14 February 2023

TfNSW Reference: SYD20/1175/07
DPE Reference: SSD-9978934

**RESPONSE TO SUBMISSION
STAGE TWO COCKLE BAY WHARF REDEVELOPMENT (SSD-9978934)
249 WHEAT ROAD, COCKLE BAY**

REV	DESCRIPTION	DATE	DRAWN	INITIAL	DATE
A	ISSUE	08/09/21	NT		
	DESCRIPTION: PRELIMINARY PLAN

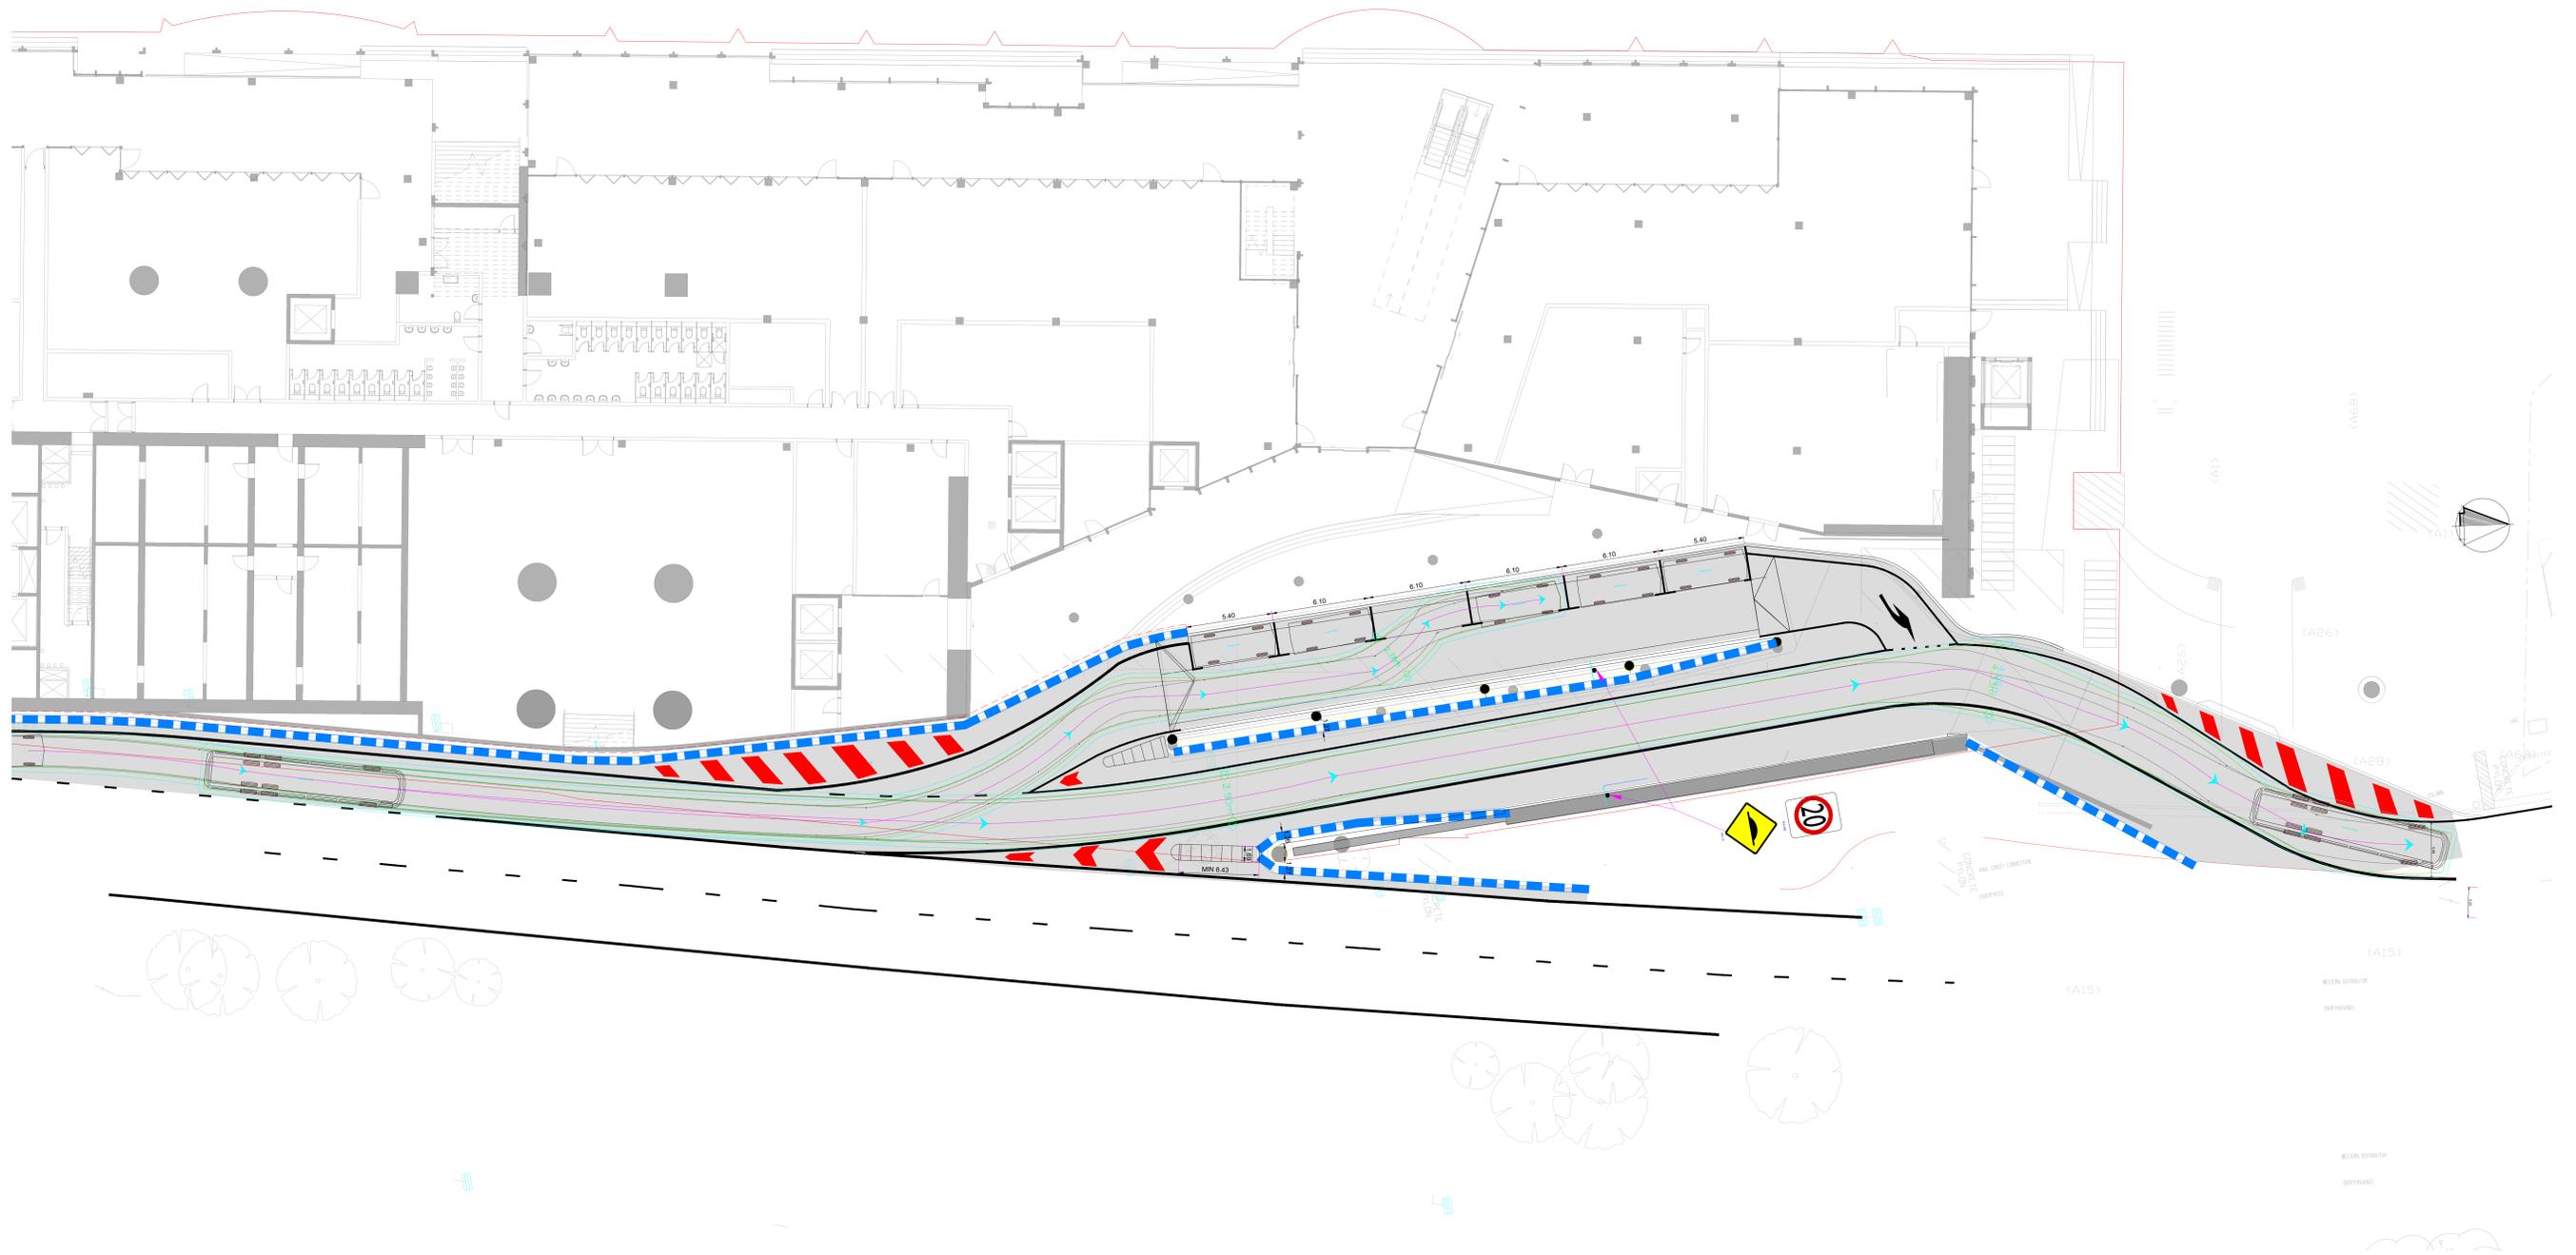
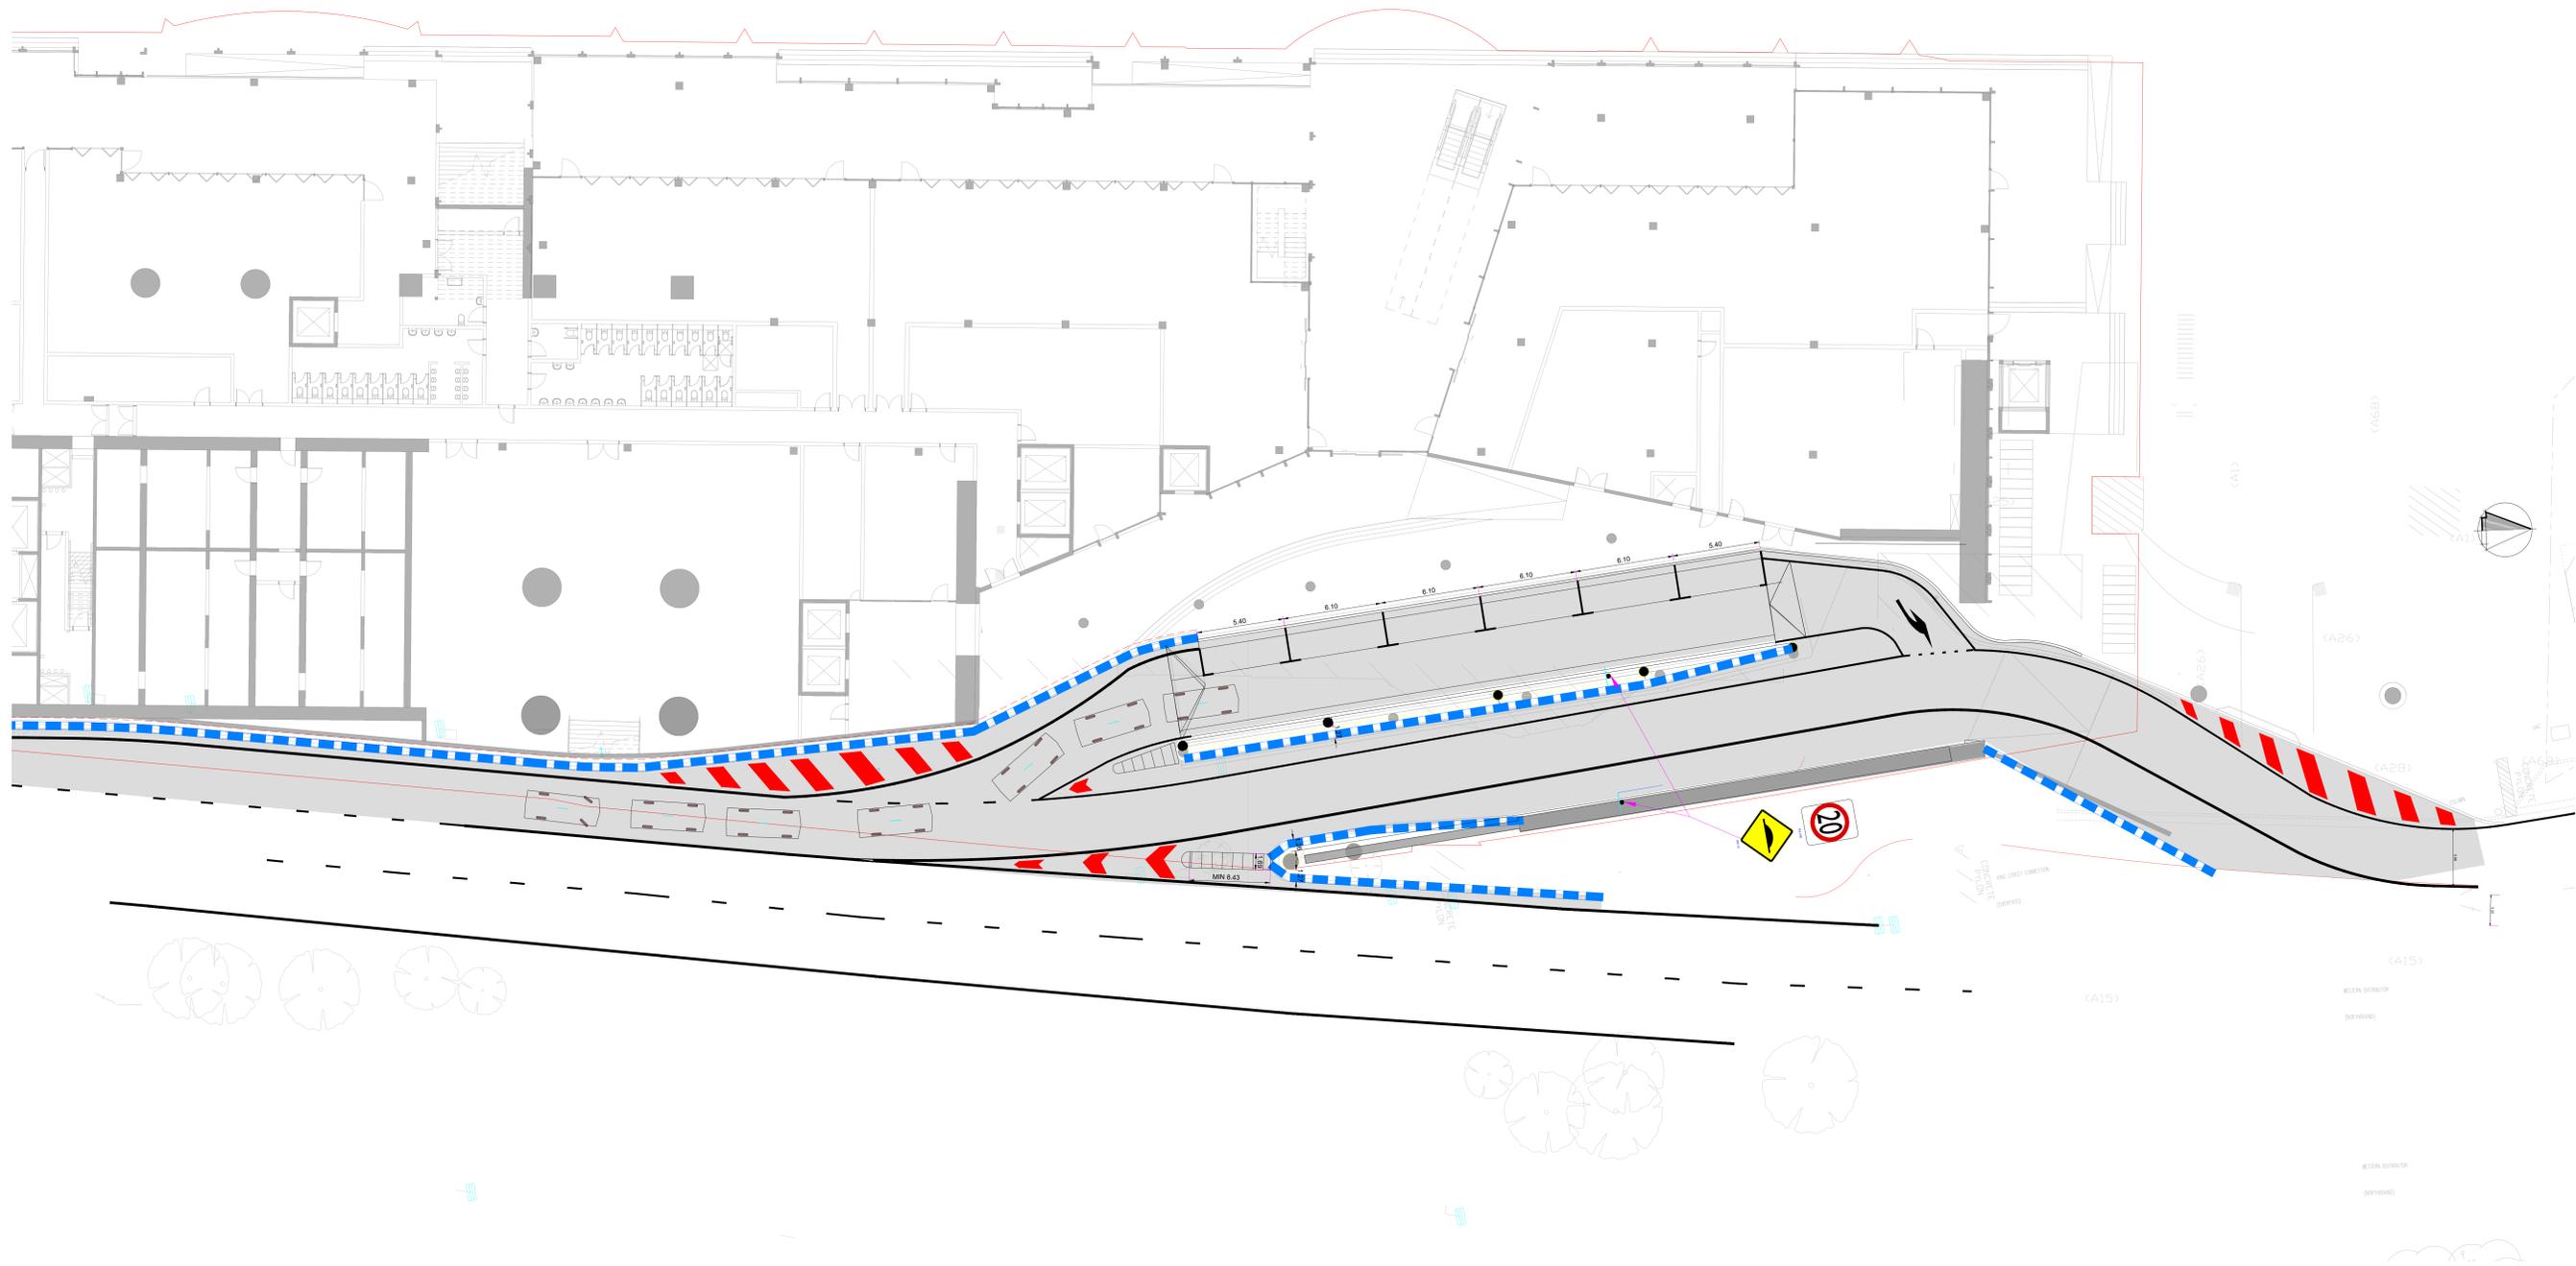
- Sight distance assessment should be based on a formalised Safe Intersection Sight Distance (SISD) checks and demonstrated in the vertical plane as well as horizontal plane. The vertical plane is particularly important due to the proposed F Type barrier.
- Appendix W – Swept Path analysis indicates HRV as the largest vehicle. However, 14.4m buses will be entering and exiting the internal service road. Swept path analysis should be updated showing the 14.4m bus traversing through the internal service driveway and egress driveway on Harbour Street.
- Concern is raised with delays and queuing from vehicles exiting the egress driveway on Harbour Street which may block access to the loading dock. This is a particular concern for:
 - MRV vehicles and Buses due to the swept path constraints at the Harbour Street intersection and access is unrestricted during peak periods.

- An assessment of the forecast demand for the porte-cochere was undertaken for the AM peak only. The demand in the PM will be generated by both the commercial and retail land uses.
- In addition, justification for the development not generating or attracting private buses or coaches has been provided. It is considered likely the retail and public domain land uses will generate some private bus or coach trips.
- Queuing assessment of the porte-cochere has been undertaken however, there could be instances where queue will overflow. This needs to be reviewed to identify measures that would ensure road safety and operational issues do not occur on Wheat Road.

- Swept path analysis should be updated to include 14.4m bus accessing the internal service road and Harbour Street access points. Designs of the internal service road and access driveways should be updated accordingly.

- Location of vehicle stopping/parking area for valet parking vehicles, taxi and pick and drop off facilities.
 - Details of the types and frequency of vehicles accessing the porte-cochere and updated swept path analysis based on the largest vehicles.
